Great North Road Solar and Biodiversity Park

Draft Statement of Common Ground with Nottinghamshire County Council

Document reference – EN010162/APP/8.4A1B

~~January~~February 2026

**Great North Road Solar and  
Biodiversity Park  
Environmental Statement**

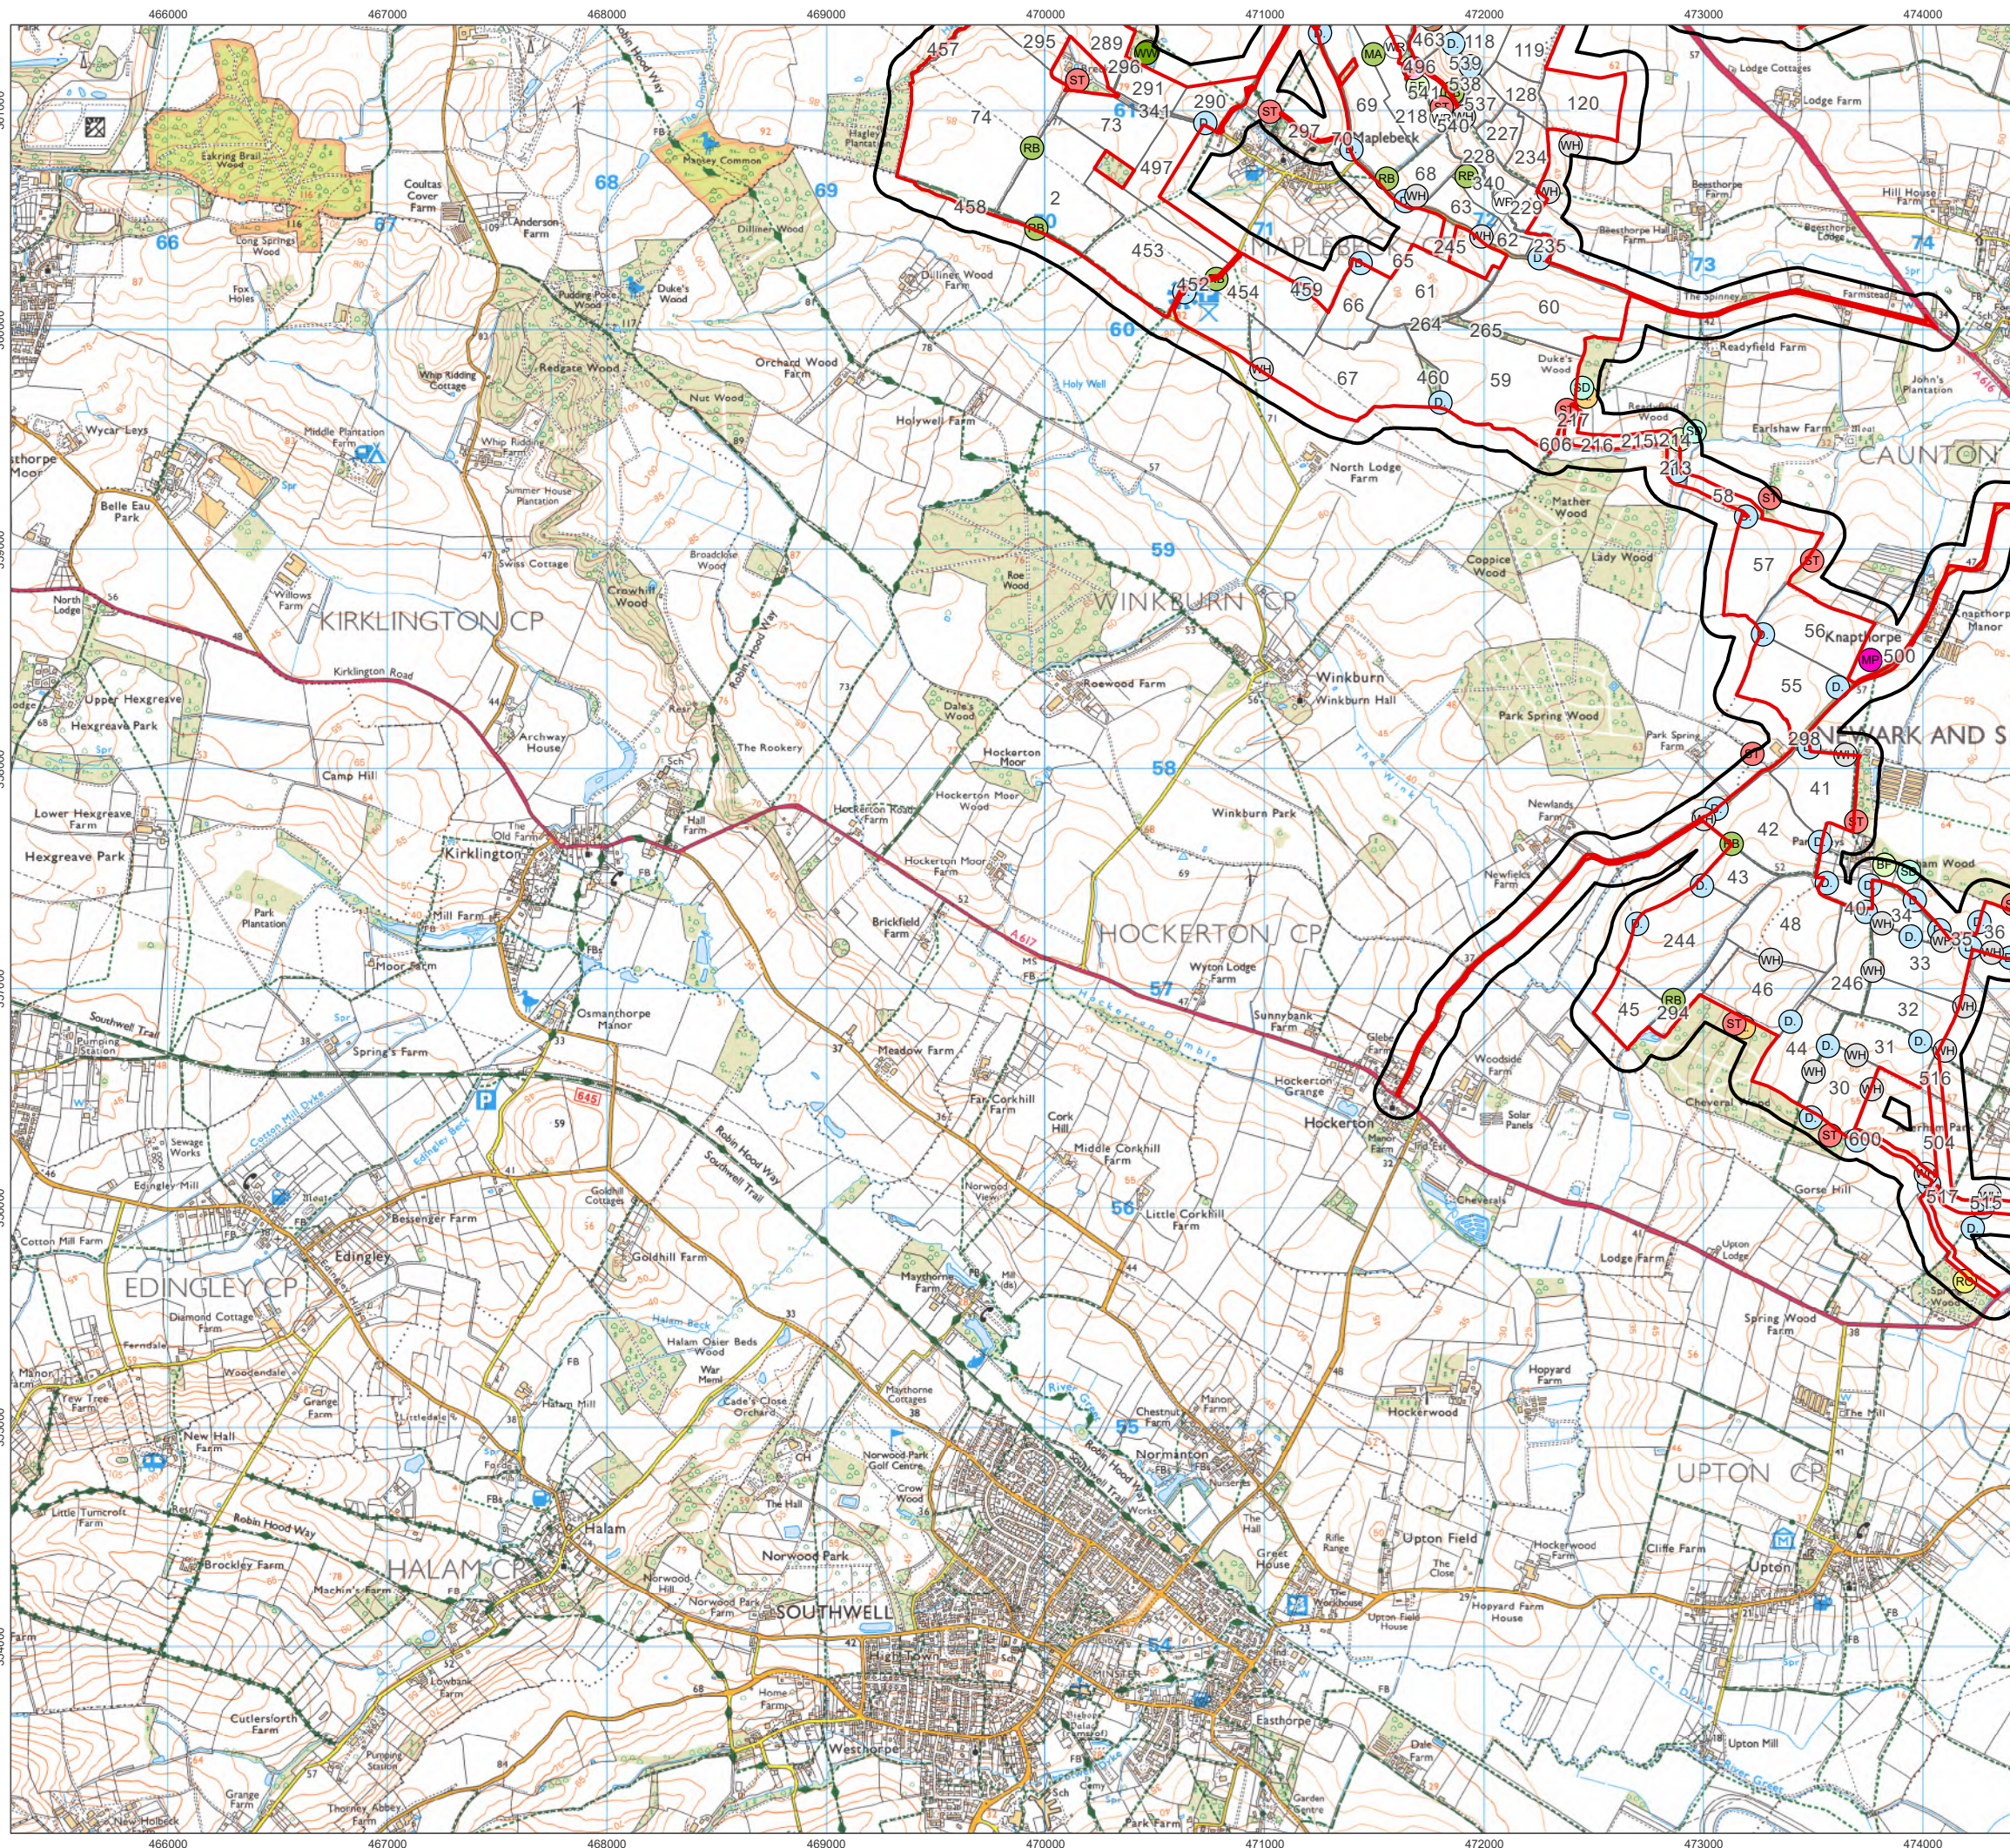
Ref	Relevant Documents	Description of Matter	Applicant's <u>NCC's</u> Position	<u>NCC's</u> Applicant's Position	Status
			<p><u>further comments on receipt of this information from the applicant.</u> <u>Our main queries prior to this are:</u> <u>Were specific nightjar and other crepuscular species surveys undertaken, given the sites location within Sherwood Forest ppSPA.</u> <u>The ES chapter claims the surveys were undertaken in line with best practice guidelines and references, but this survey methodology requires a minimum of 6 surveys, and not four which the applicant has undertaken. In addition, this survey methodology also states: "Any deviation in the number of surveys must be supported with detailed and robust justification. Additional survey effort may need to be considered for large-scale projects with the potential to have significant impacts on birds, and/or for high profile, sensitive projects". Further justification for the level of survey effort undertaken is therefore sought.</u> <u>The site has been assessed as regional value to breeding birds</u></p>	<p><u>engagement since Deadline 1 to resolve this issue.</u></p> <p><u>Deadline 2 Position:</u> <u>The baseline studies and survey methods for breeding birds are presented in ES Volume 4, Appendix A8.4: Breeding Birds Baseline [EN010162/APP/6.4.8.4] [APP-217]. Section A8.4.2.2 (paragraph 24) provides justification for the survey methods and section A8.4.2.4 describes potential limitations and how these have been addressed.</u> <u>An assessment of the effects of the Development on breeding birds is provided in section 8.9.10 of ES Volume 2, Chapter 8: Ecology and Biodiversity [EN010162/APP/6.2.8] [APP-051].</u> We have not had sight of the breeding bird survey results appendix and therefore will provide further comments on receipt of this information from the applicant. Our main queries prior to this are:</p>

Ref	Relevant Documents	Description of Matter	Applicant's <u>NCC's</u> Position	<u>NCC's</u> Applicant's Position	Status
			<p><u>with SPI, LBAP, LWS- qualifying species and Schedule 1 WCA species recorded. Should further analysis of this be undertaken given the potential qualification of a LWS feature. The baseline studies and survey methods for breeding birds are presented in ES Volume 4, Appendix A8.4: Breeding Birds Baseline [EN010162/APP/6.4.8.4] [APP-217]. Section A8.4.2.2 (paragraph 24) provides justification for the survey methods and section A8.4.2.4 describes potential limitations and how these have been addressed.</u></p> <p><u>An assessment of the effects of the Development on breeding birds is provided in section 8.9.10 of ES Volume 2, Chapter 8: Ecology and Biodiversity [EN010162/APP/6.2.8] [APP-051].</u></p>	<p>Were specific nightjar and other crepuscular species surveys undertaken, given the sites location within Sherwood Forest ppSPA.</p> <p>The ES chapter claims the surveys were undertaken in line with best practice guidelines and references, but this survey methodology requires a minimum of 6 surveys, and not four which the applicant has undertaken. In addition, this survey methodology also states: "Any deviation in the number of surveys must be supported with detailed and robust justification. Additional survey effort may need to be considered for large scale projects with the potential to have significant impacts on birds, and/or for high profile, sensitive projects". Further justification for the level of survey effort undertaken is therefore sought.</p> <p>The site has been assessed as regional value to breeding birds with SPI, LBAP, LWS- qualifying species and Schedule 1 WCA</p>

2.1.3	RR	Protected Species - Breeding Birds	<p><u>Current Position:</u> <u>TBC</u></p> <p><u>Deadline 2 Position:</u> <u>We have not had sight of the breeding bird survey results appendix and therefore will provide</u></p>	<p><u>Current Position:</u> <u>The Applicant notes that the NCC comment has not been updated, but understands that NCC Officers have confirmed agreement on this matter. This follows ongoing</u></p>	Agreed
